# EARLY GRADING AND EROSION CONTROL PLANS

## SPRINGS AT WATERVIEW

EL PASO COUNTY, STATE OF COLORADO

PROJECT SPRINGS AT WATERVIEW
 SHEET TITLE GENERAL DETAILS
 FROM _____ TO _____
 JOB NO. 0102.1 SHEET 3 OF 6

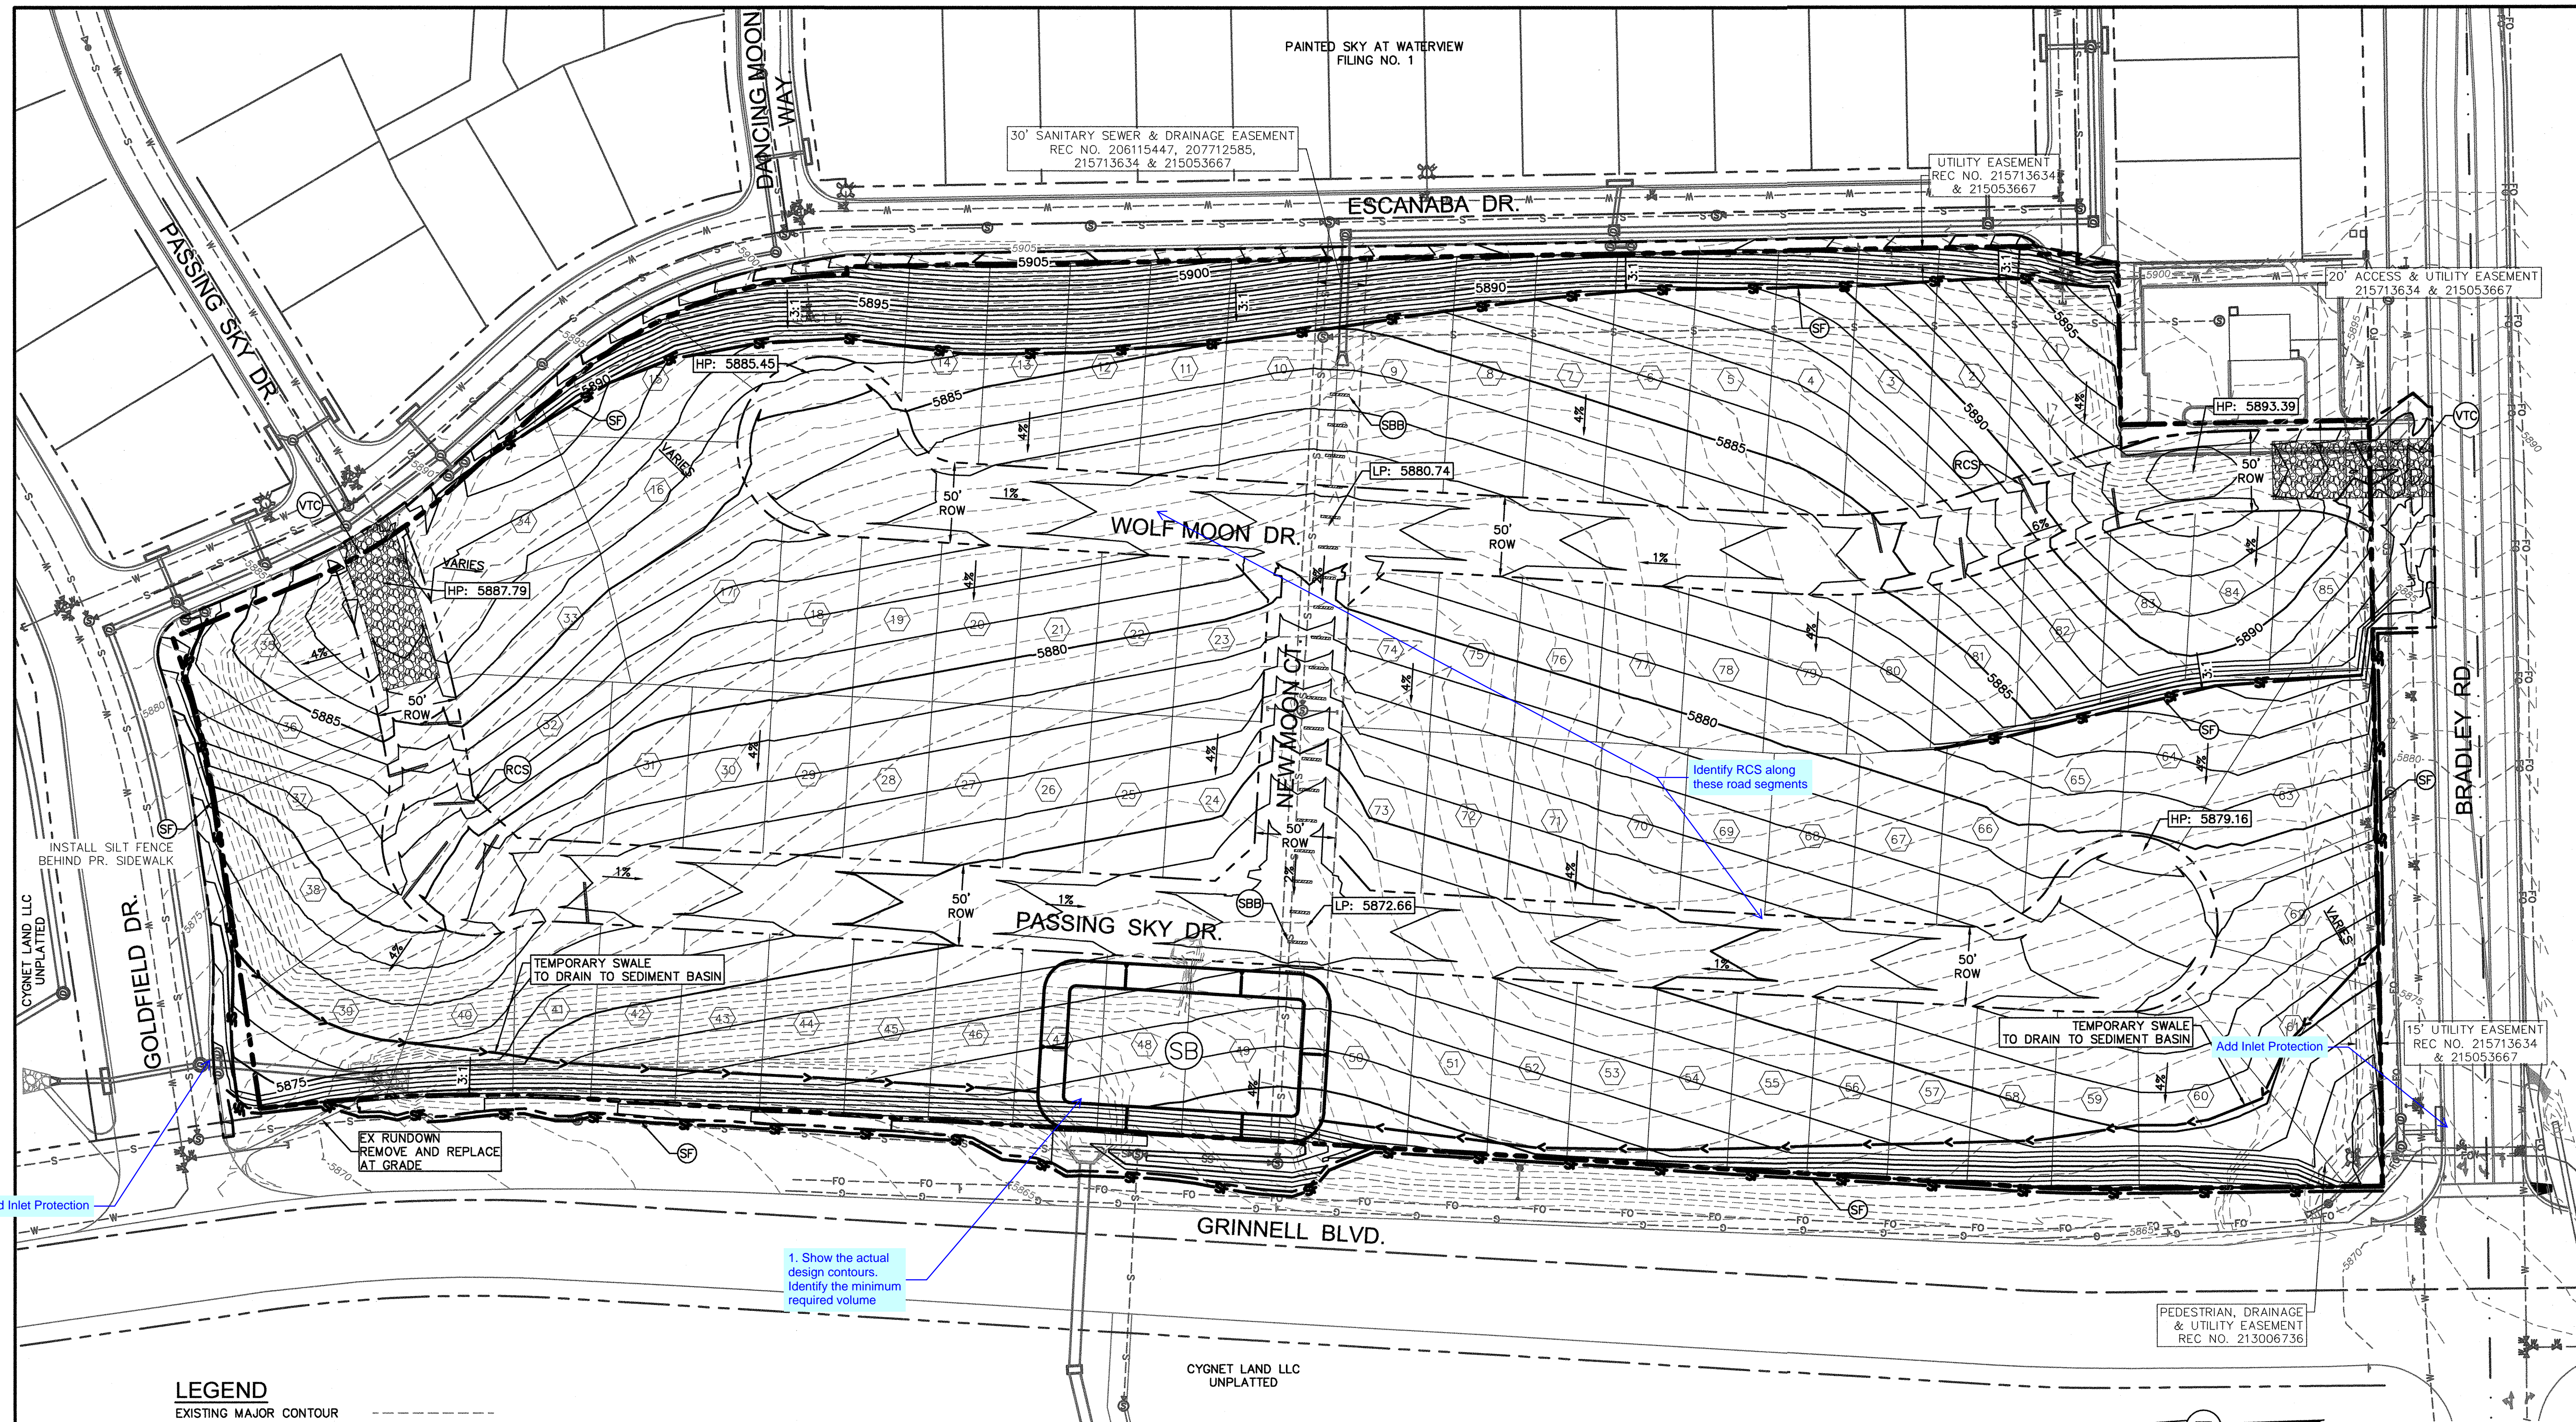
Revise header to 'El Paso County' Unresolved.
